APPLICANT RESPONSE TO COMMENTS (V3)
ROLLIN RIDGE ESTATES – COMMERCIAL PUD (PUD 183)
October 31, 2018

Summary of Comments on Rollin Ridge staff comments 10-2-18 with LSC Responses (working).pdf

Figure 2b
**Commercial
 Site Plan**

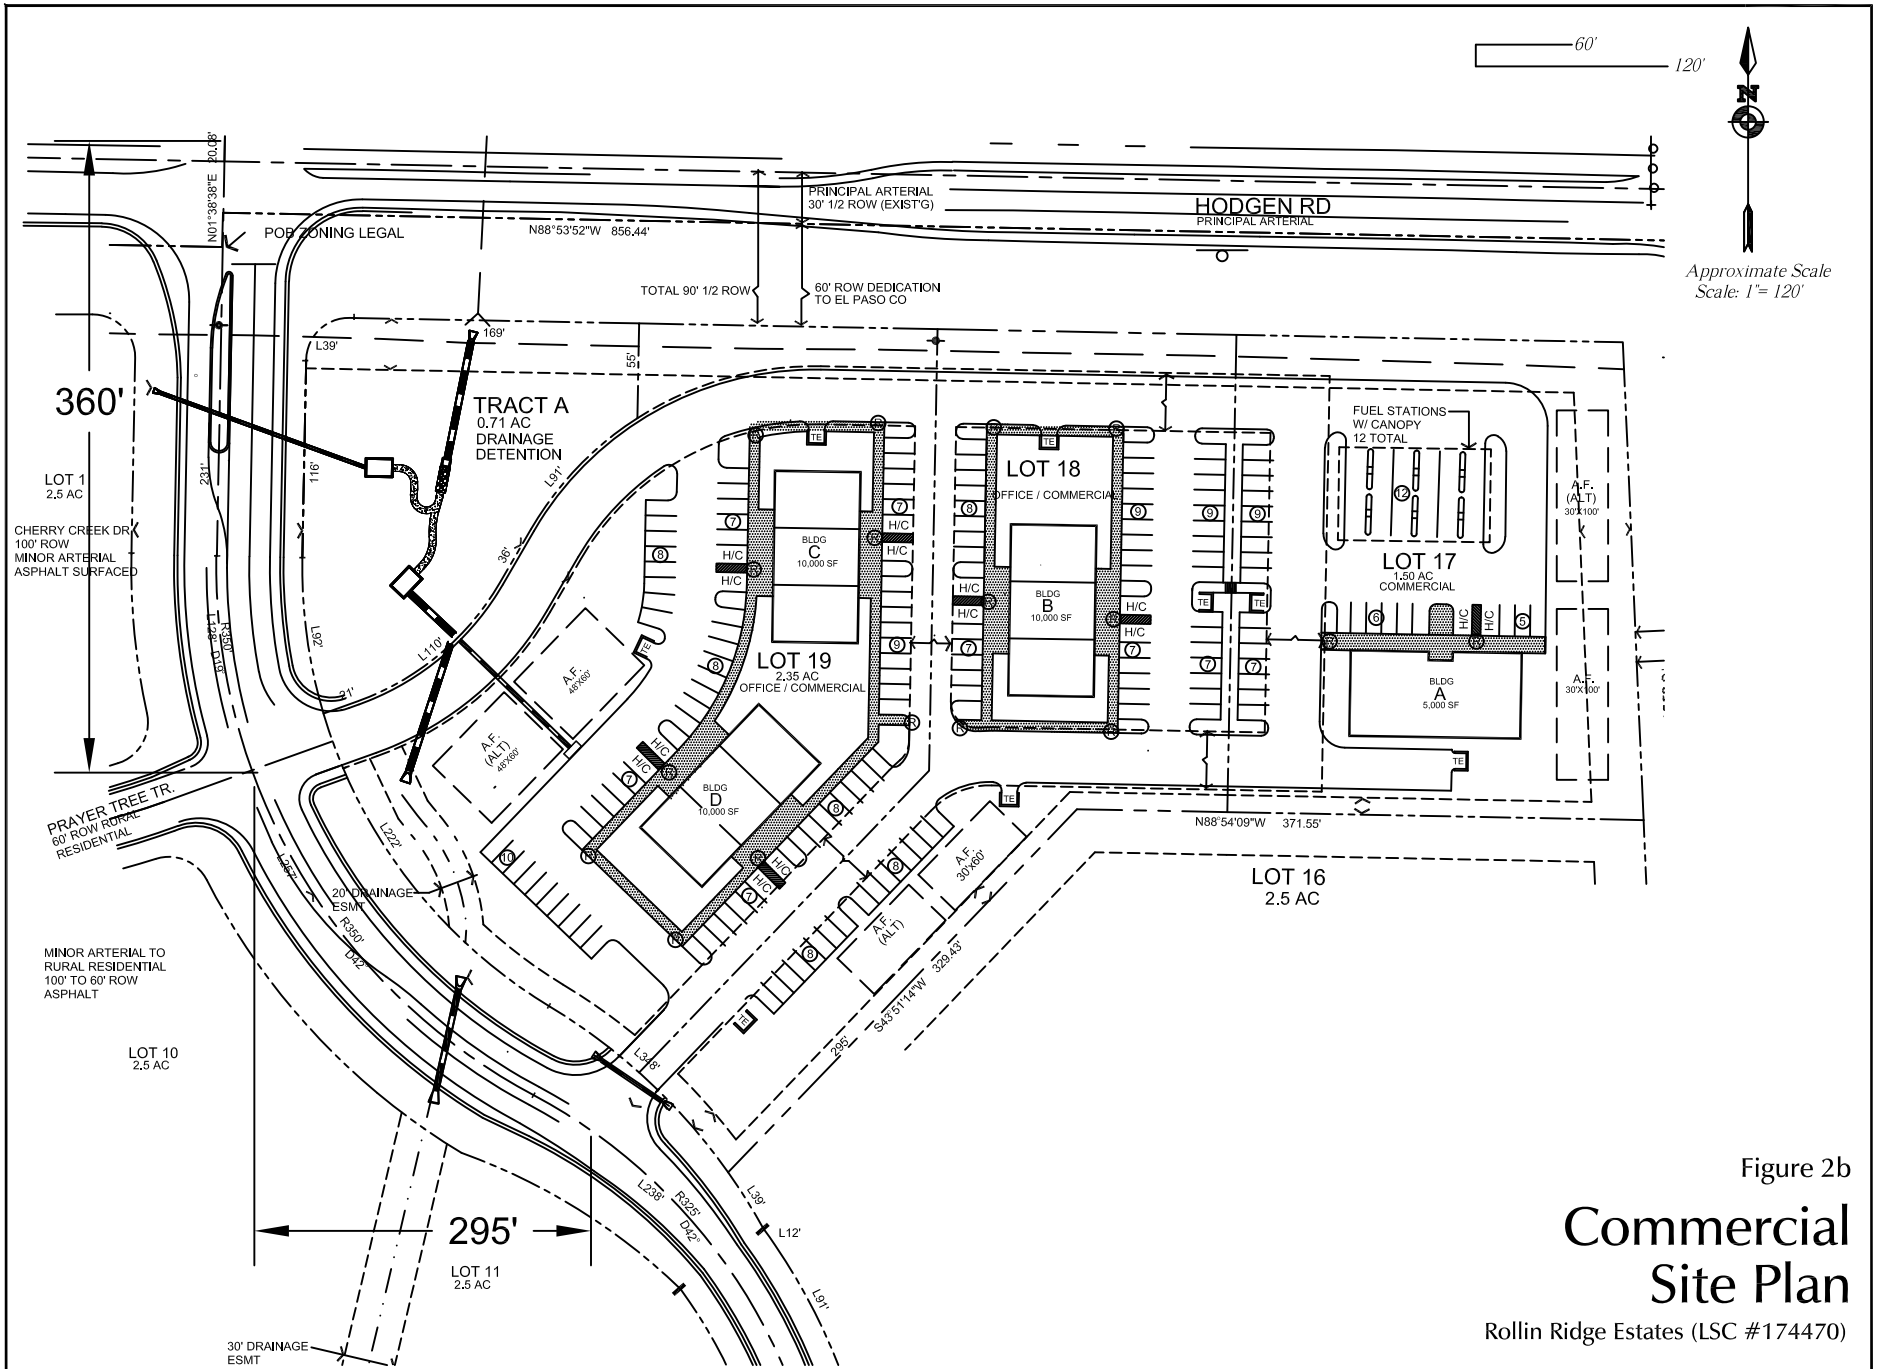
[A deviation is required for this spacing.](#)
